ROLLING MEADOWS/ BULL HILL LETTER OF INTENT Sketch Plan

January 18, 2023 (REV1)

**SKP02**  
SHEET 02 OF 03

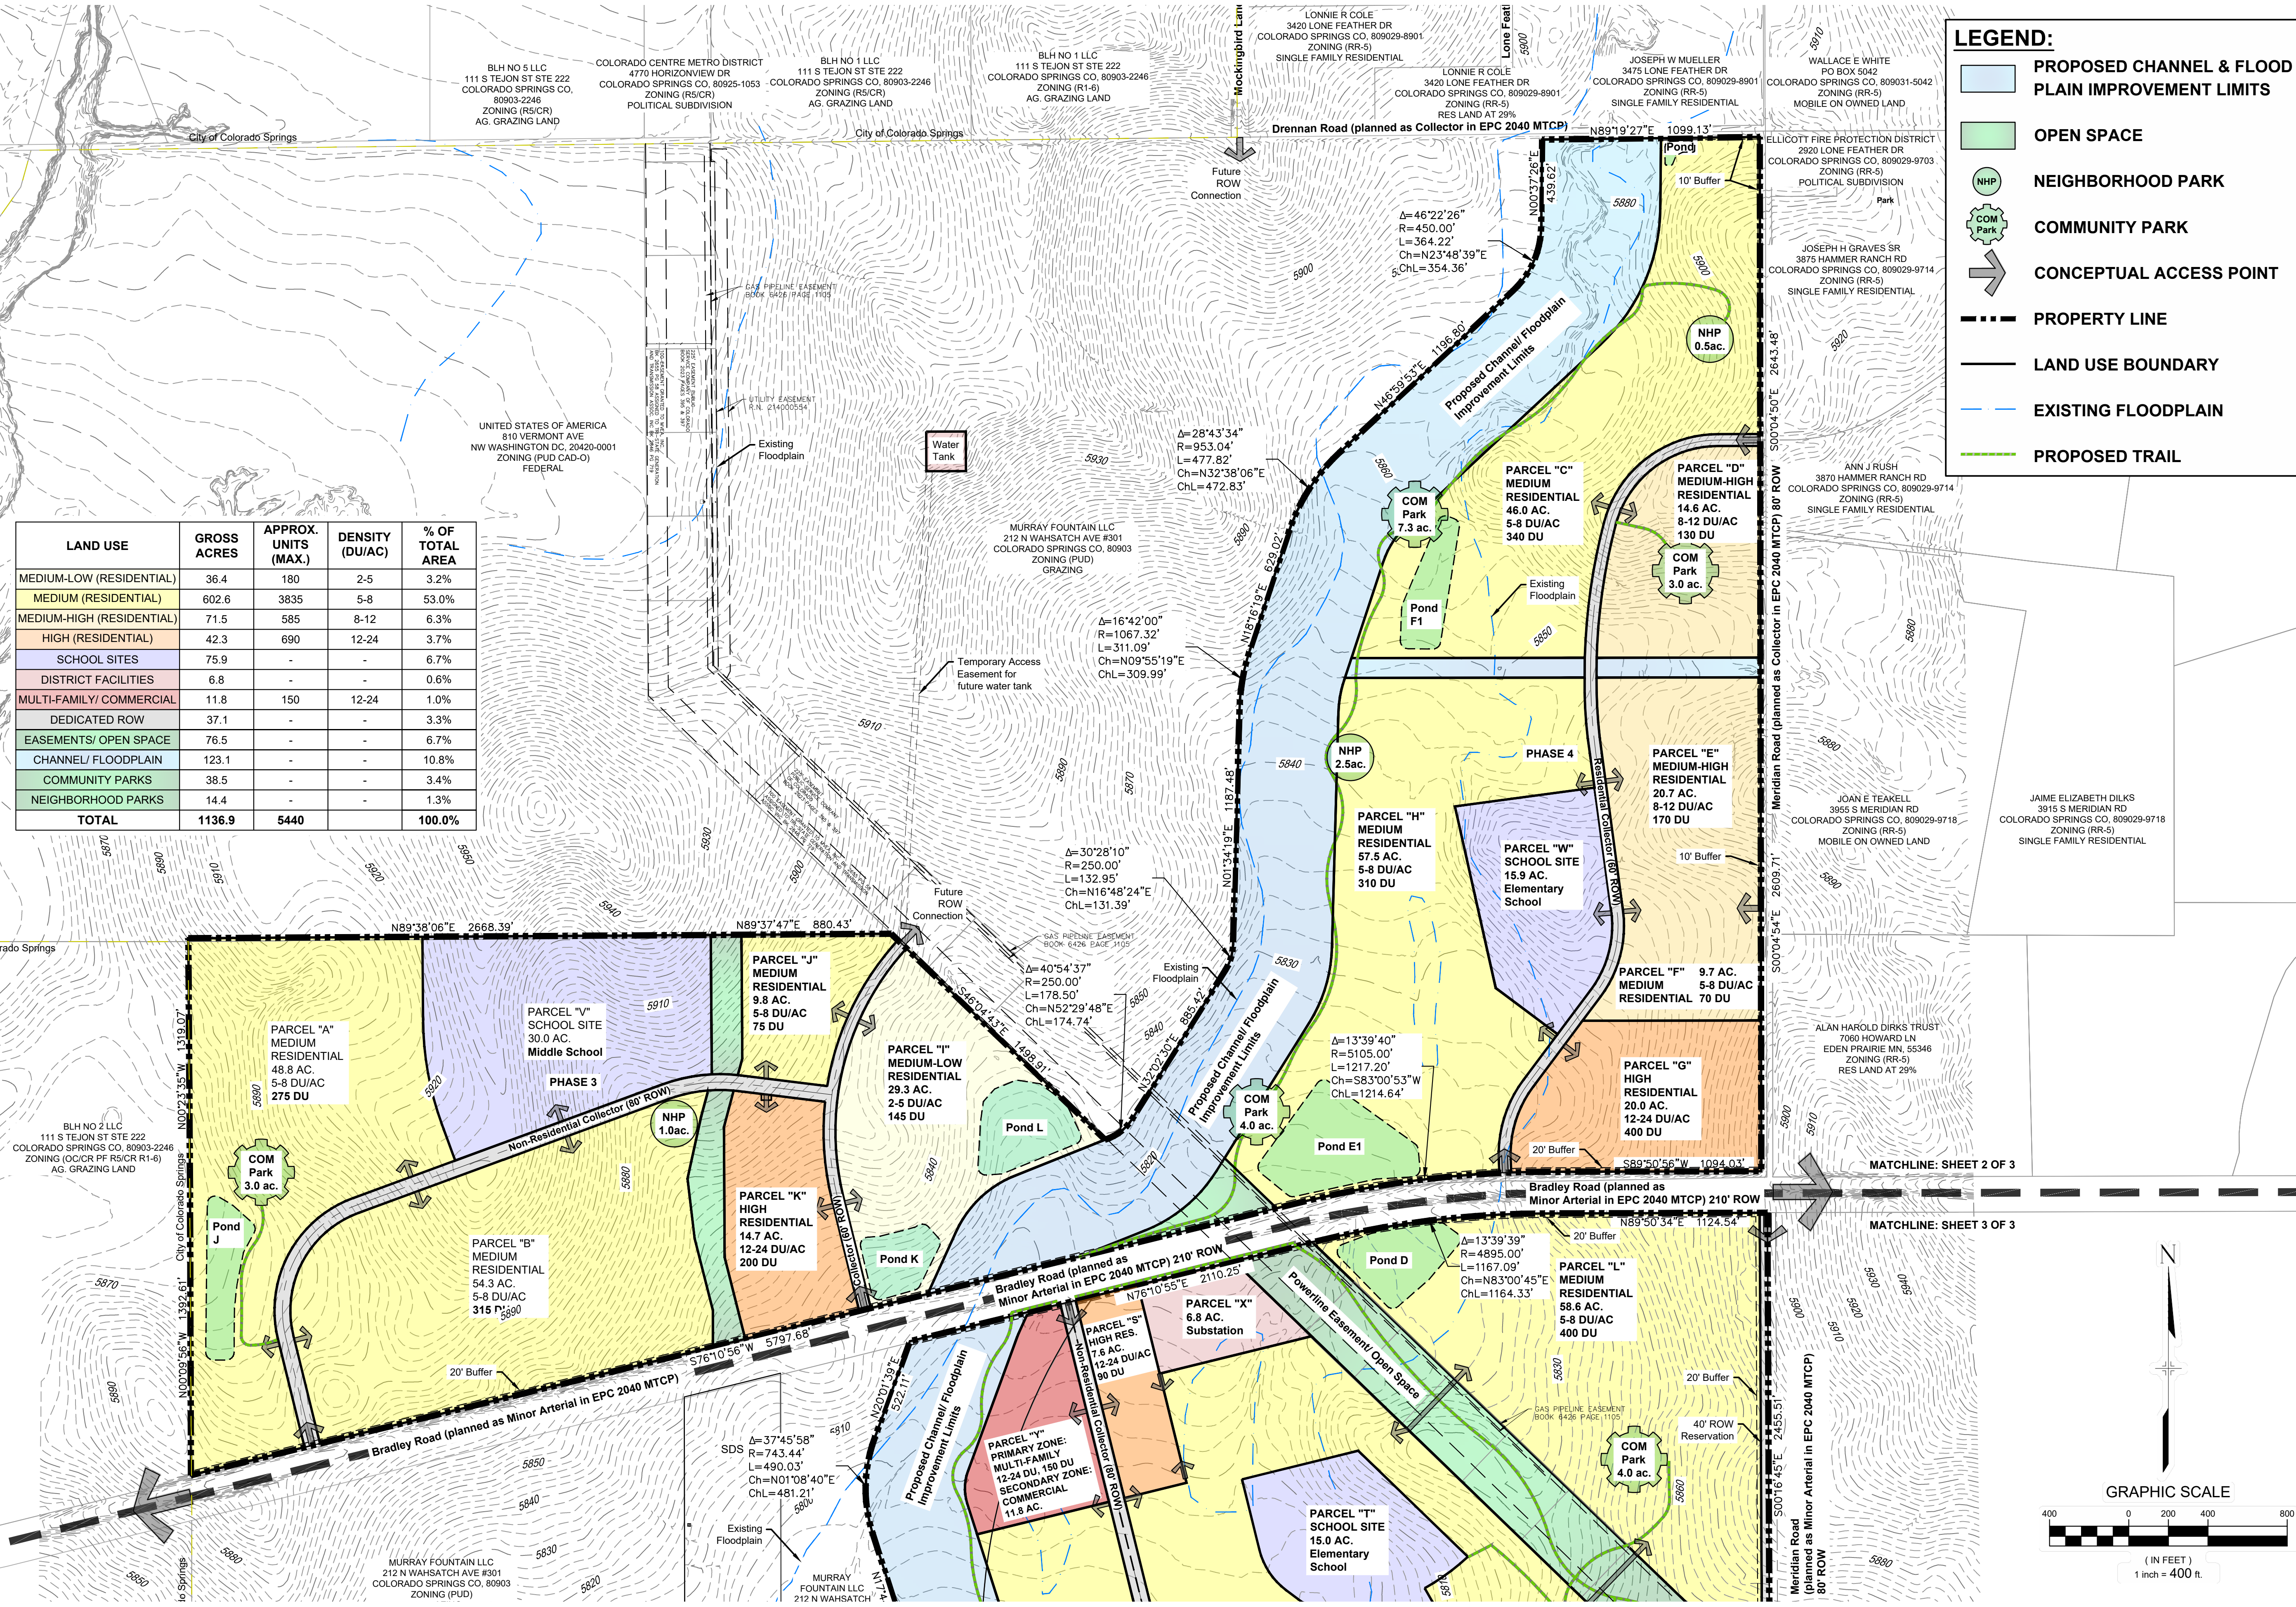
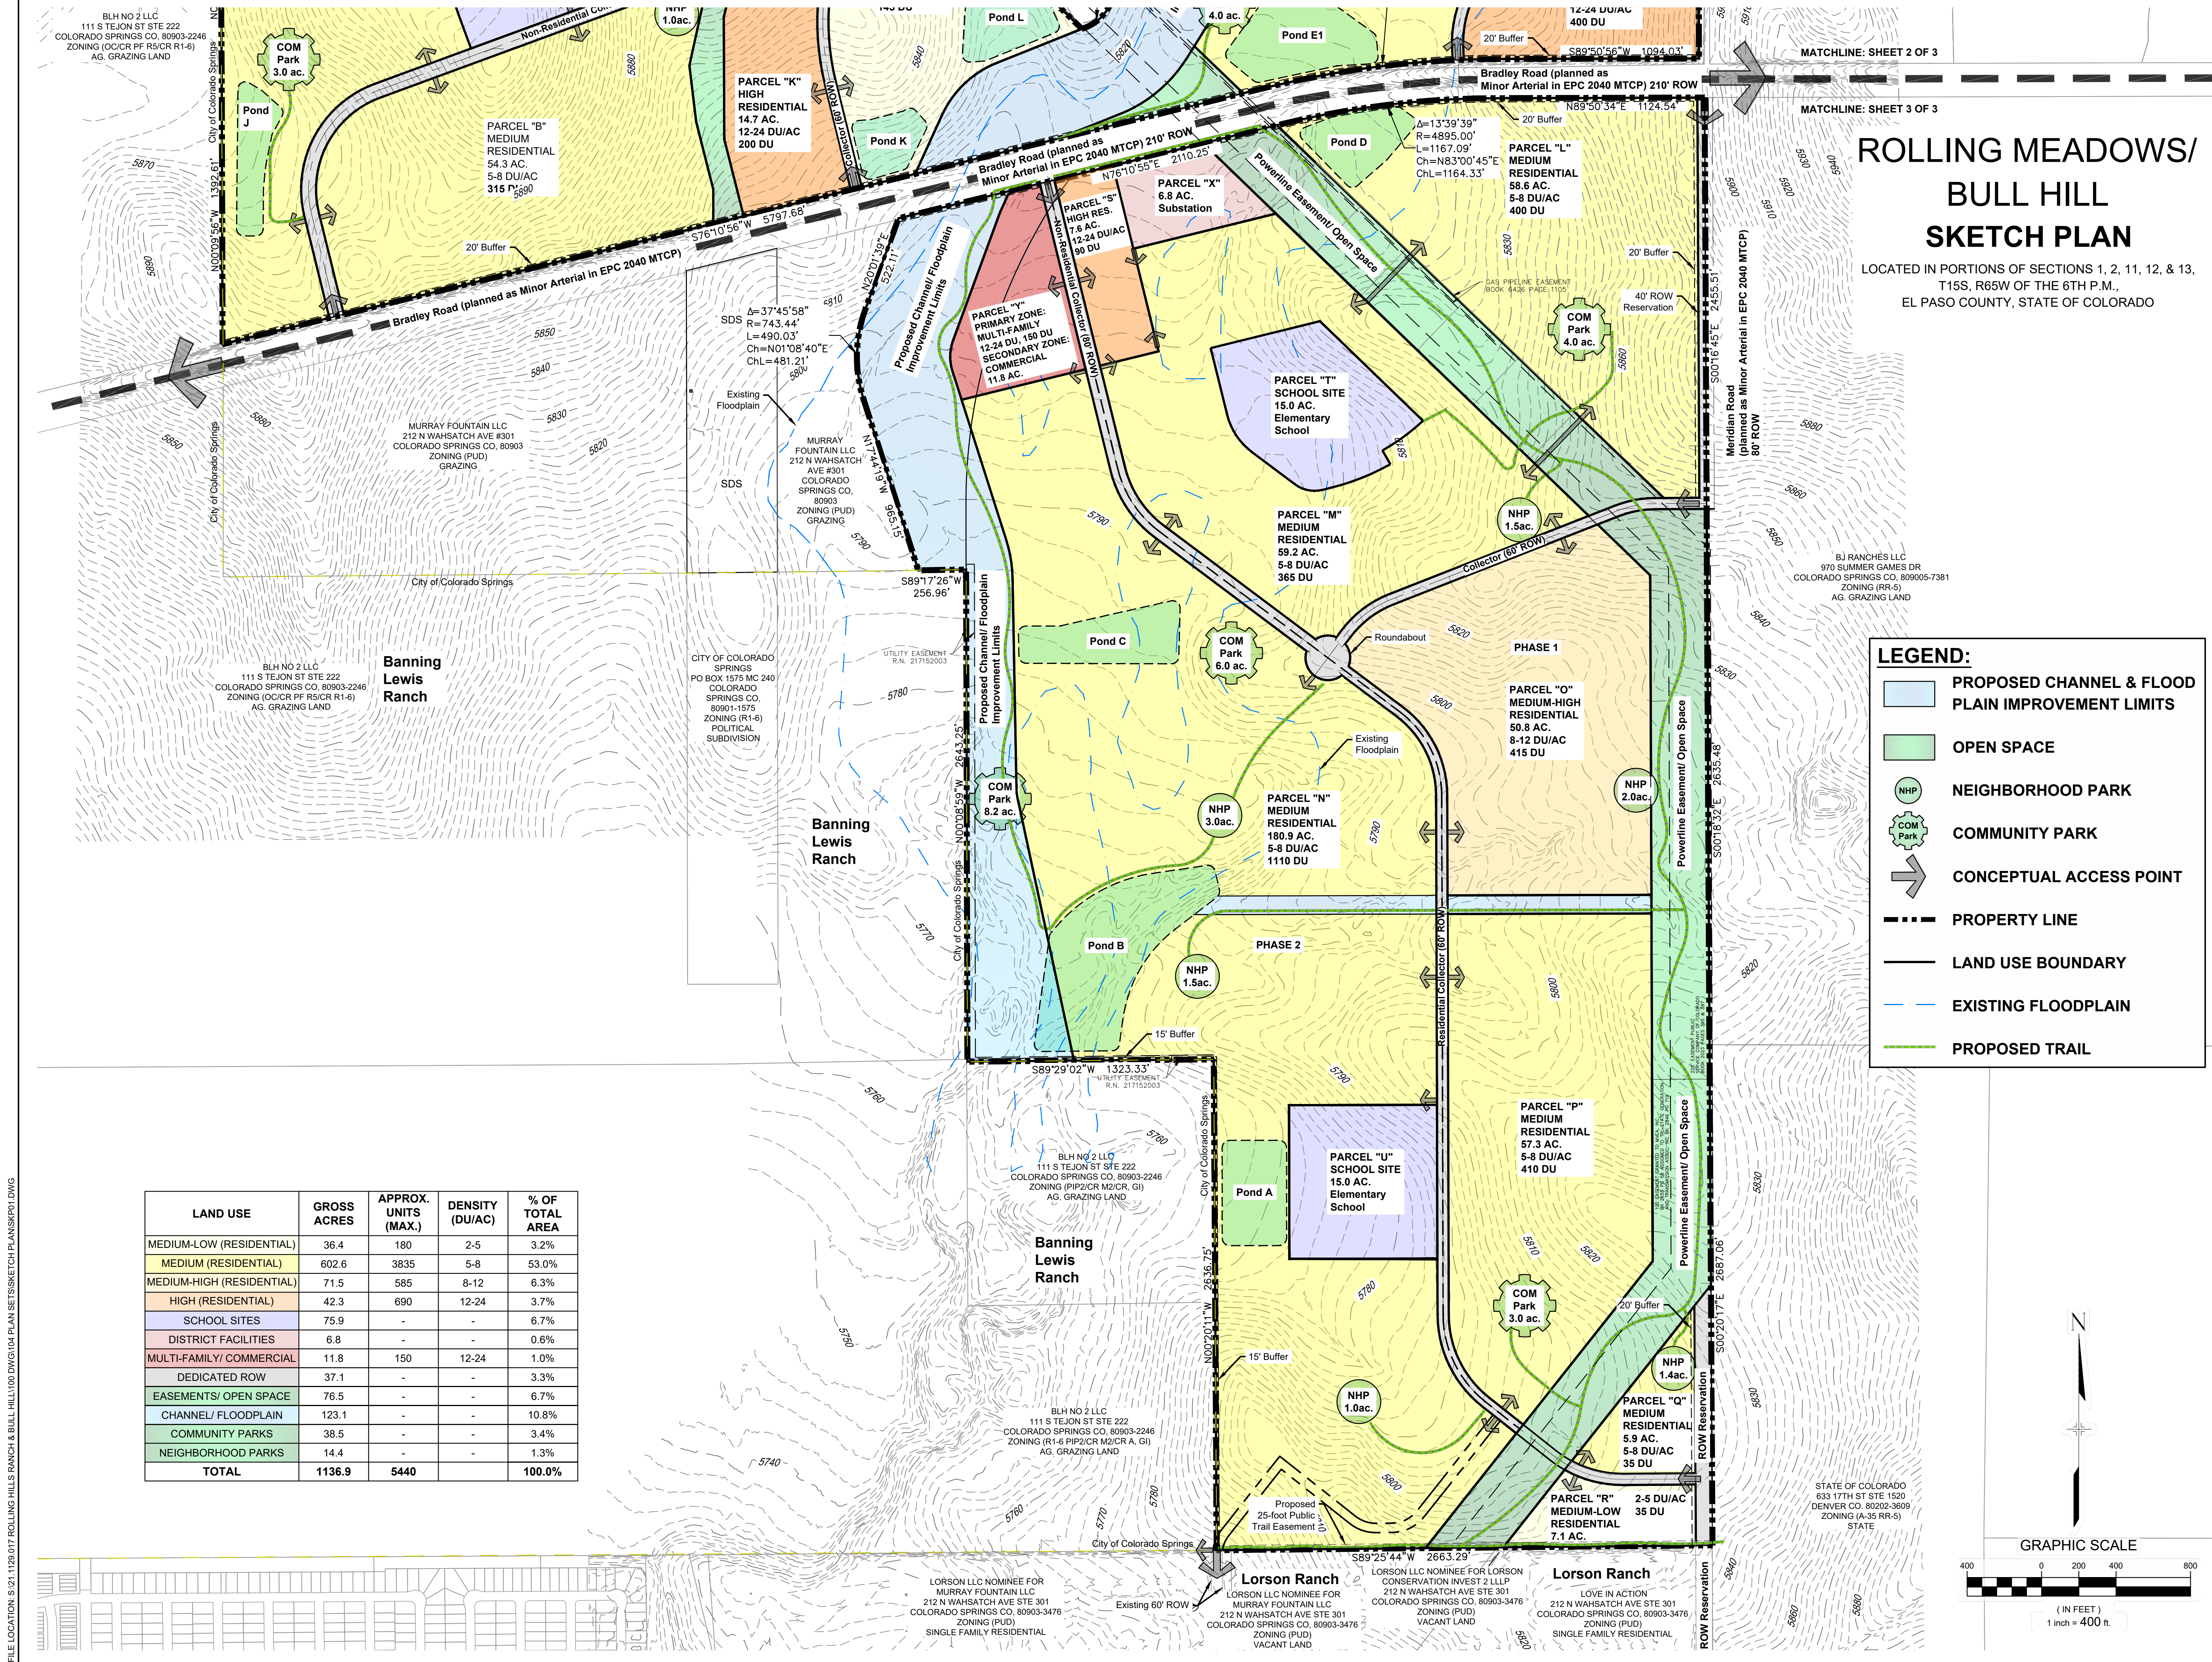
please break these categories up Multi-family residential high density verses commercial

Sketch Plan Area (I added this because its still not clear that this is one sketch plan not 2- the acreages are not adding up)

the combined acreage above is much higher in the table
